Acceptance of Applications Checklist

June 2024

Morecambe Offshore Wind Farm Section 55 Acceptance of Applications Checklist

Figure: 7.1      Drawing No: PC1165-RHD-ES-OF-DR-Z-0008

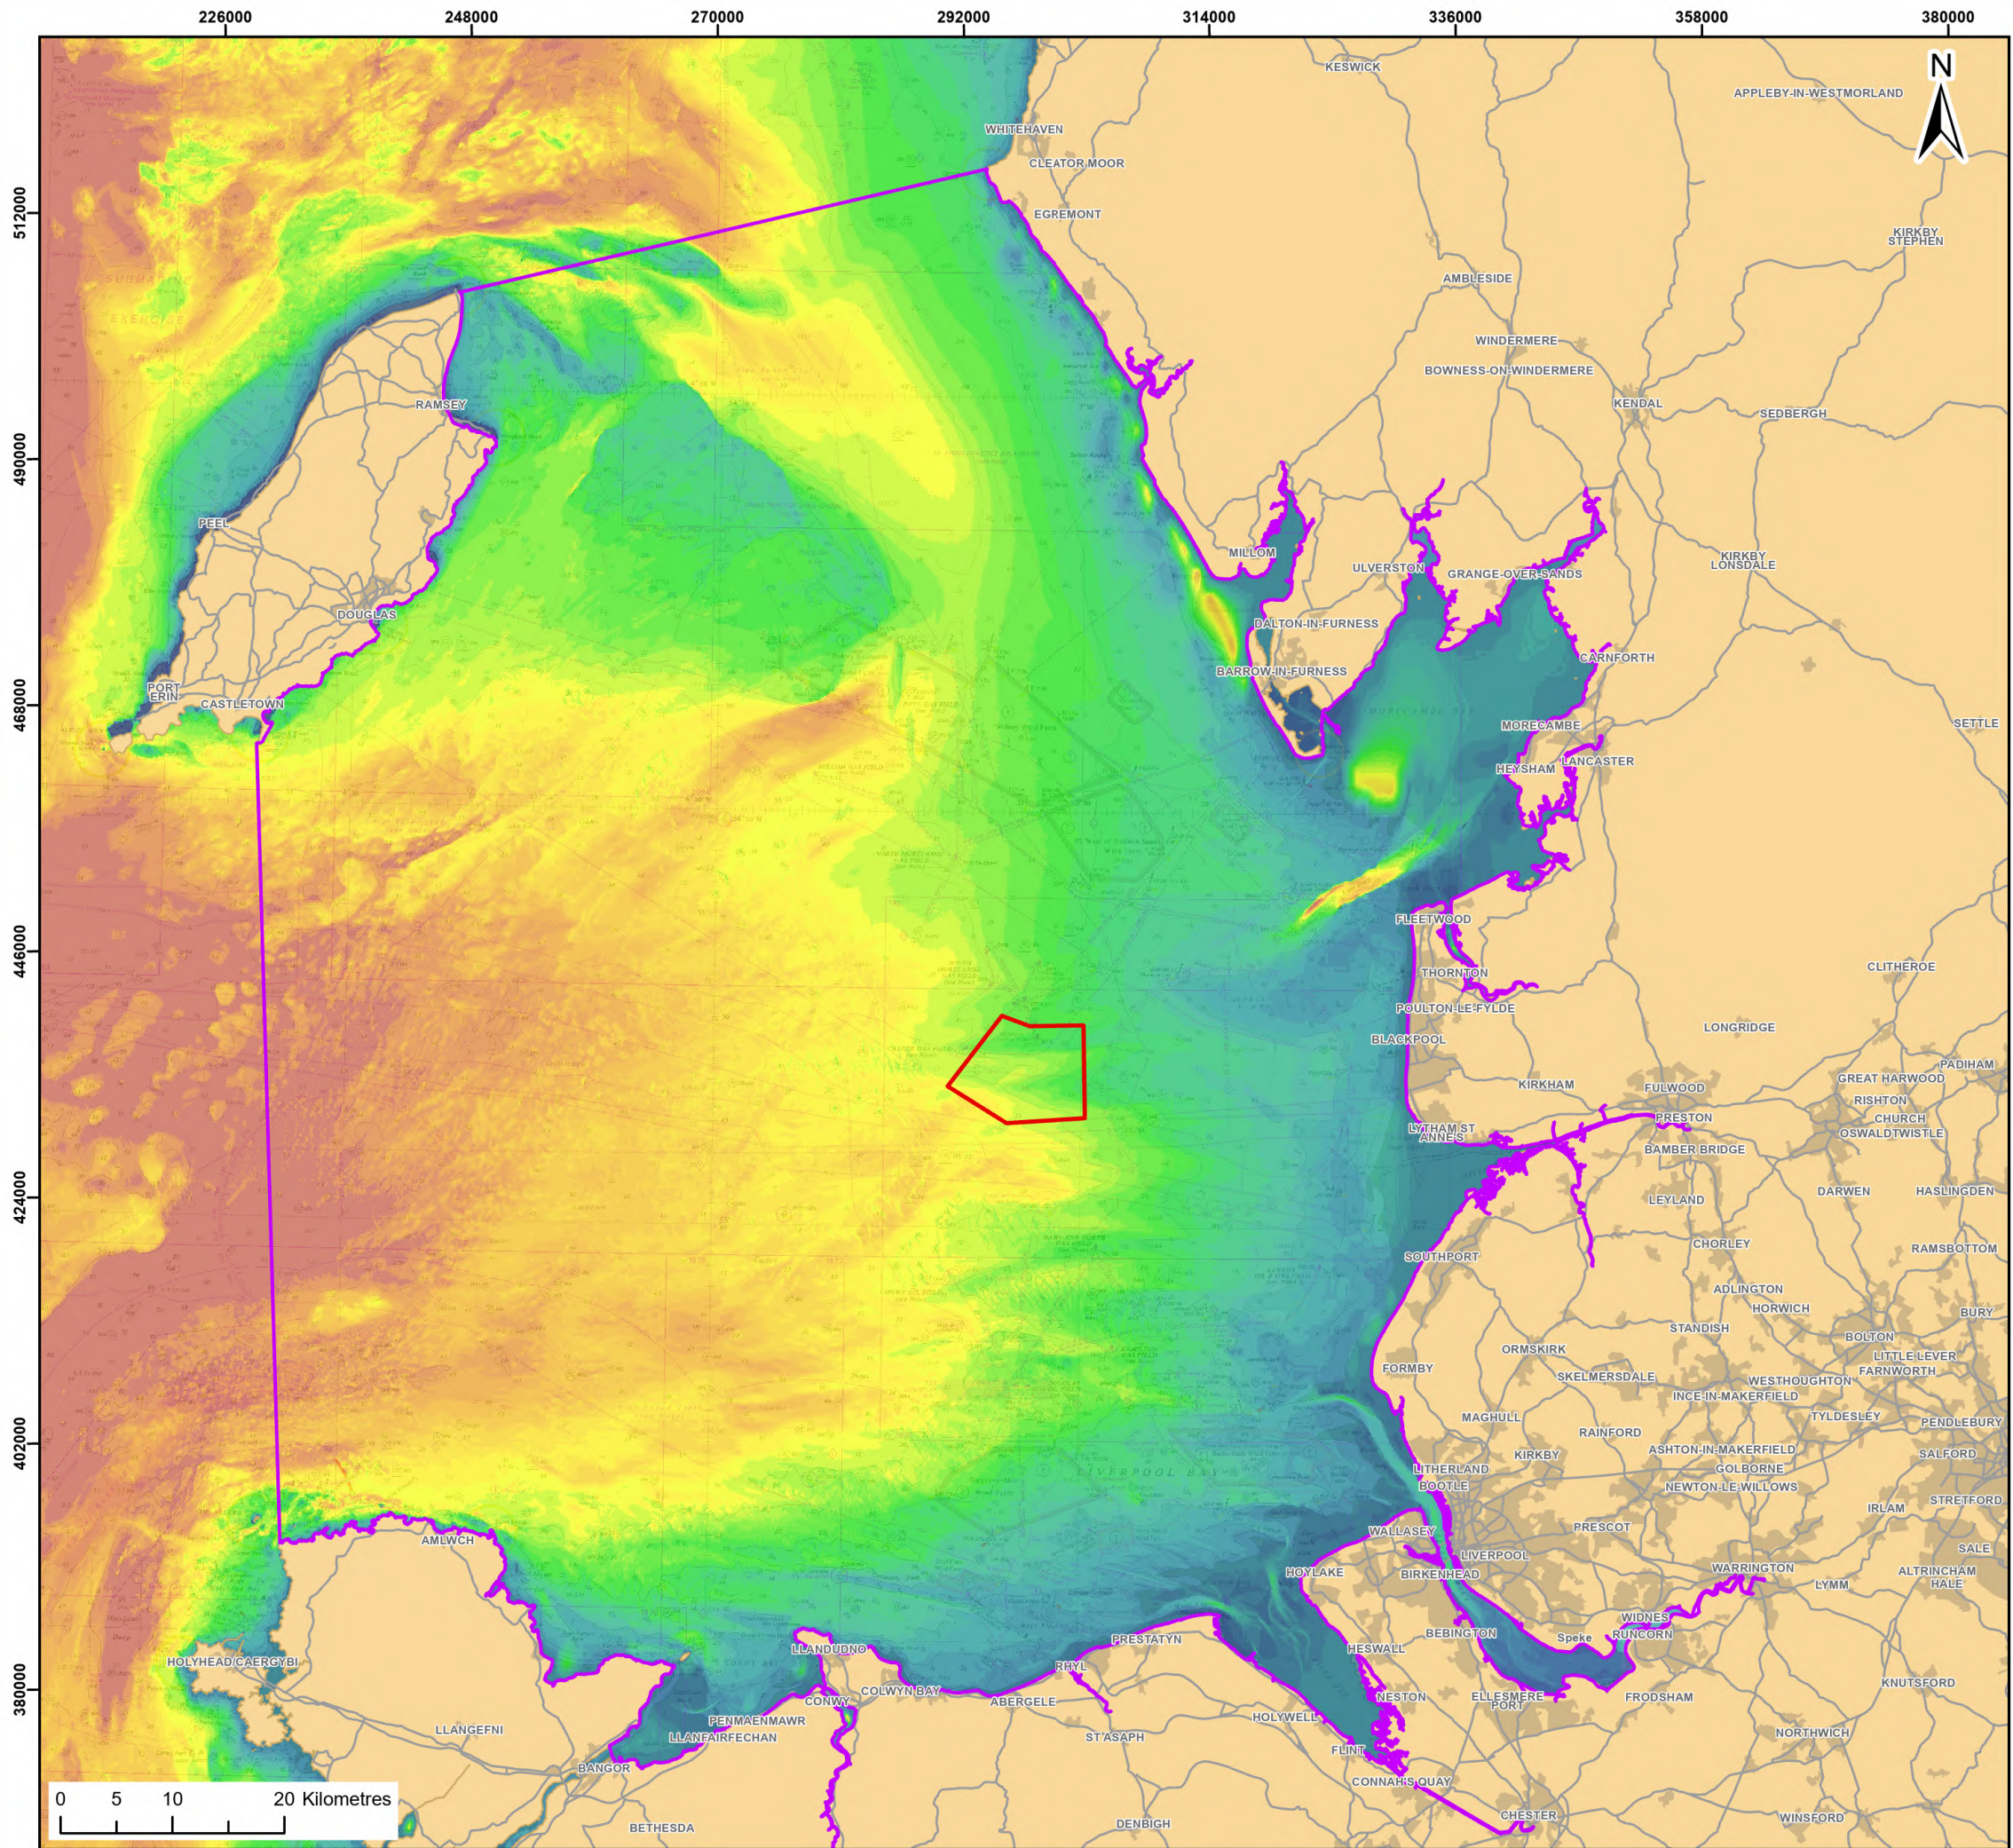
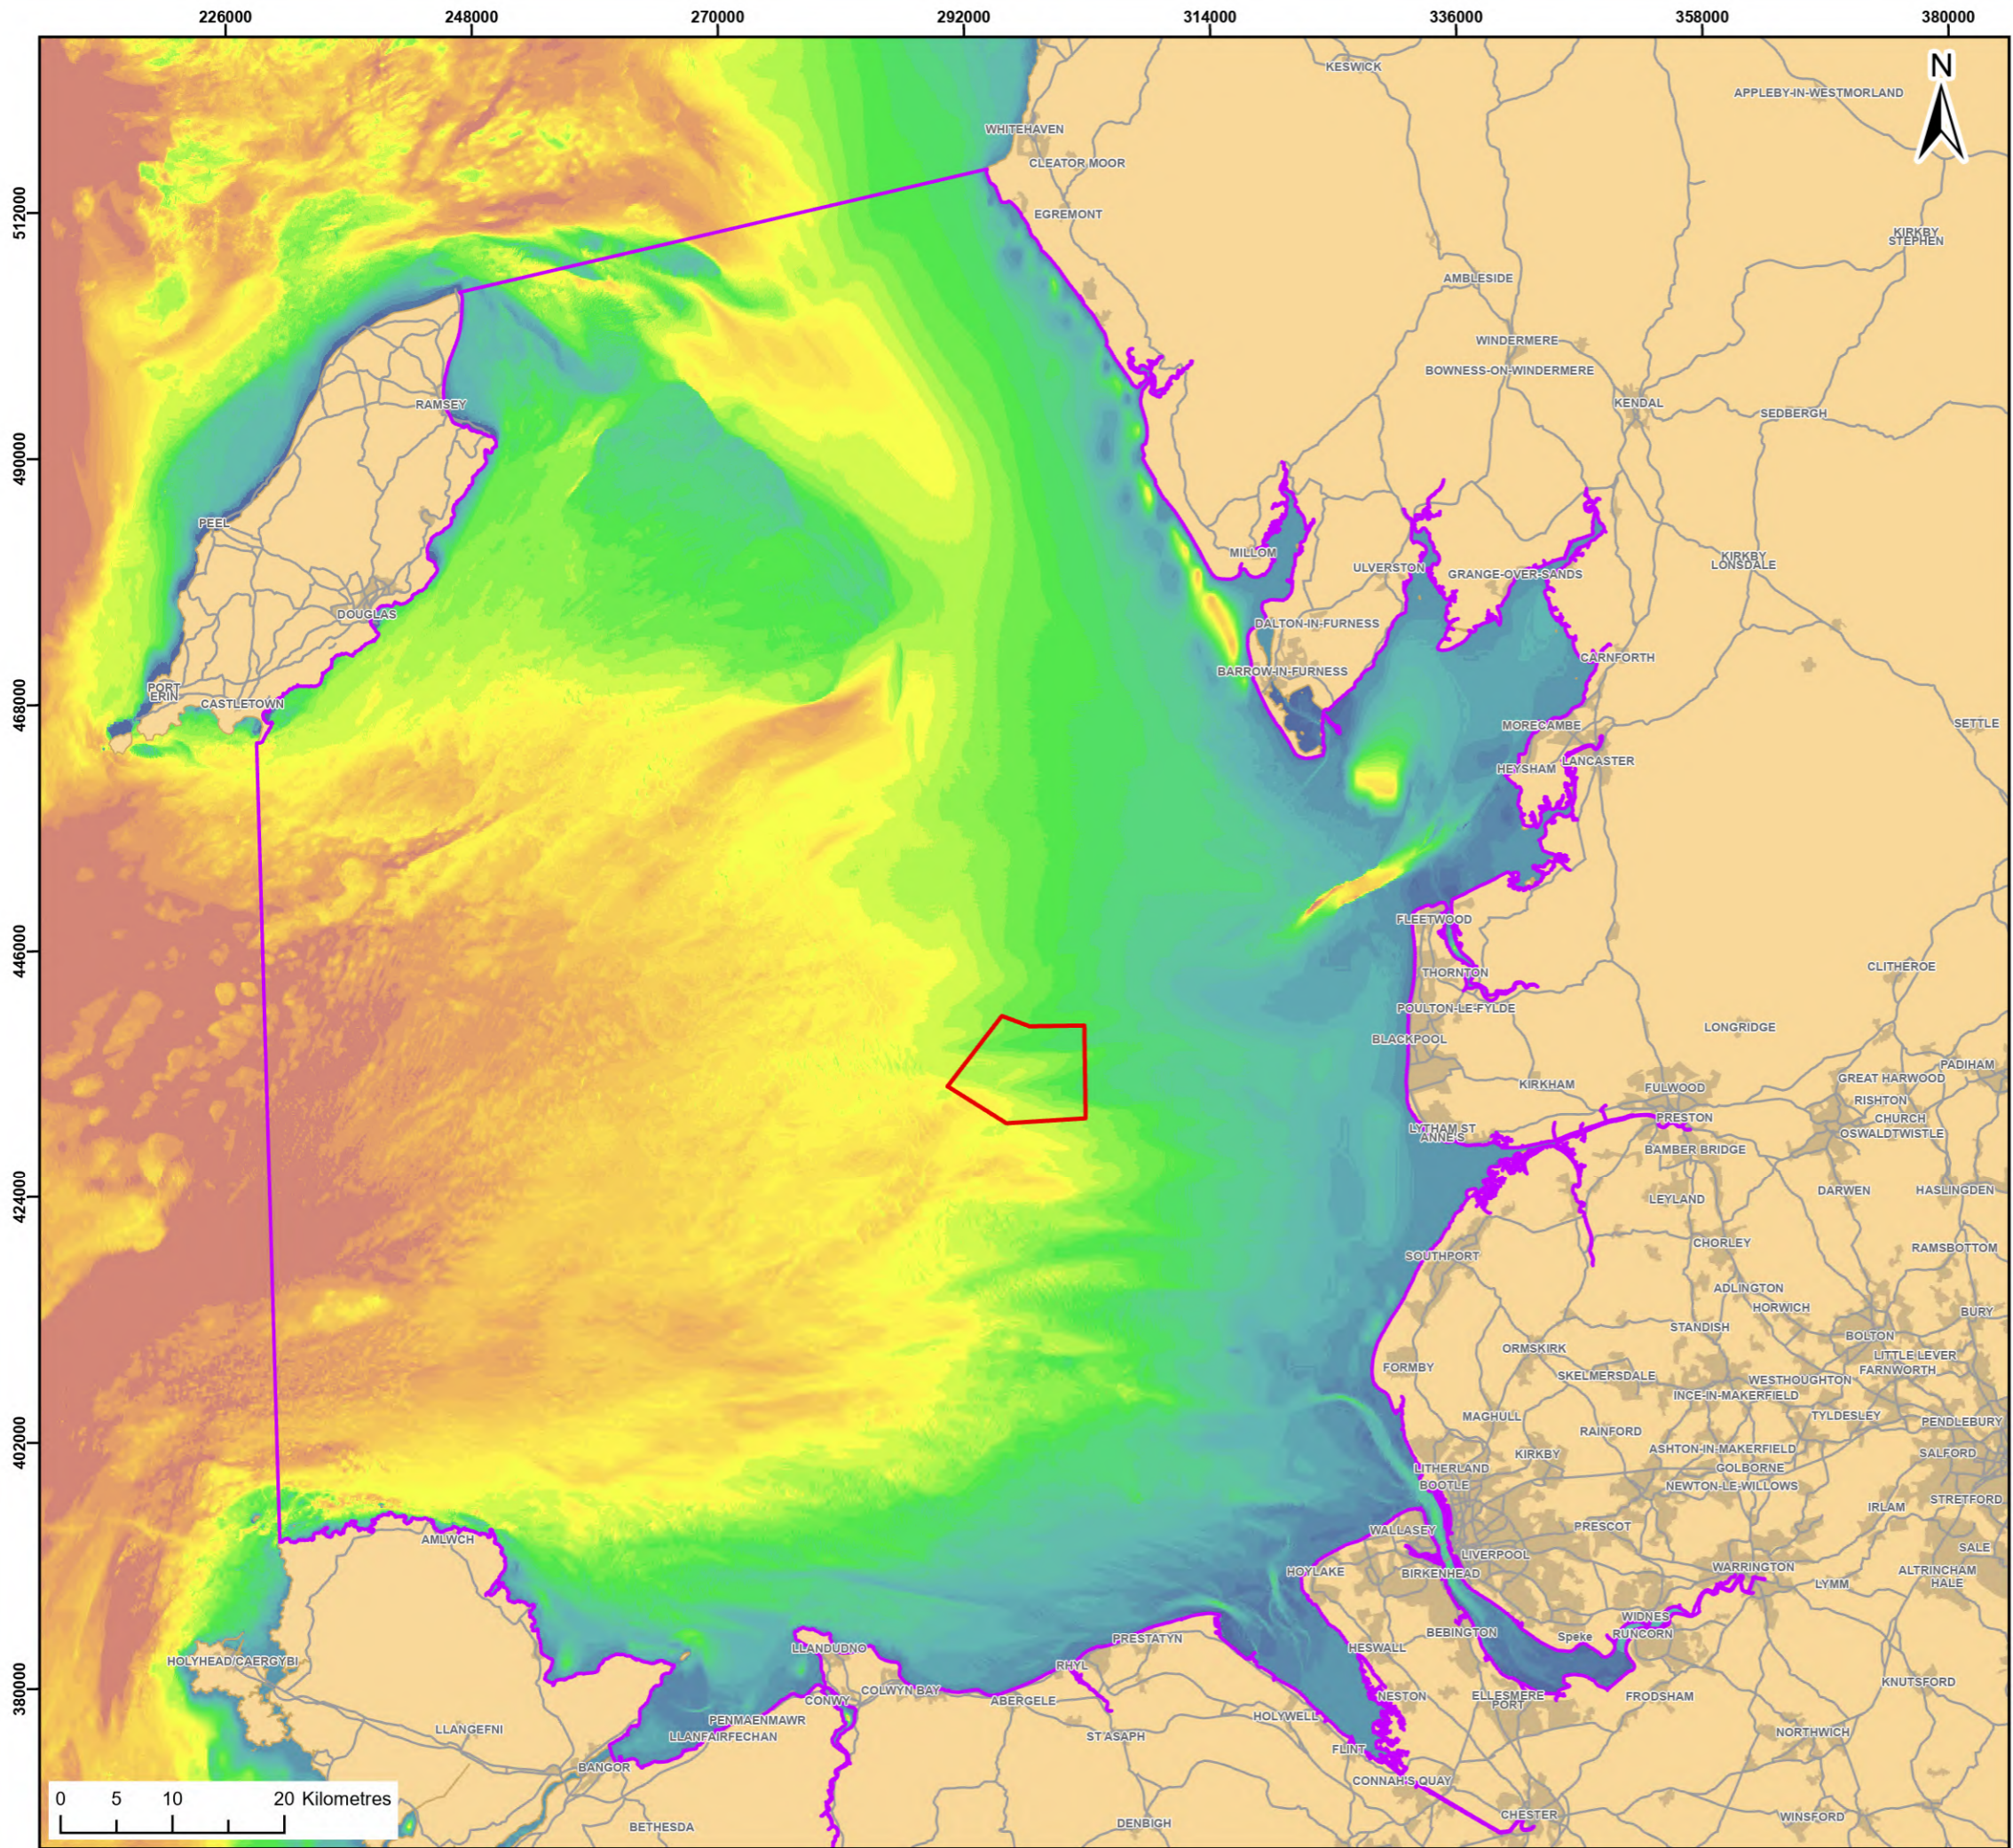
- The blue shaded area to left of the legend not identifiable, appears that the Applicant may have placed red line boundary over an existing navigational map, labelling unclear but may be seabed depth.
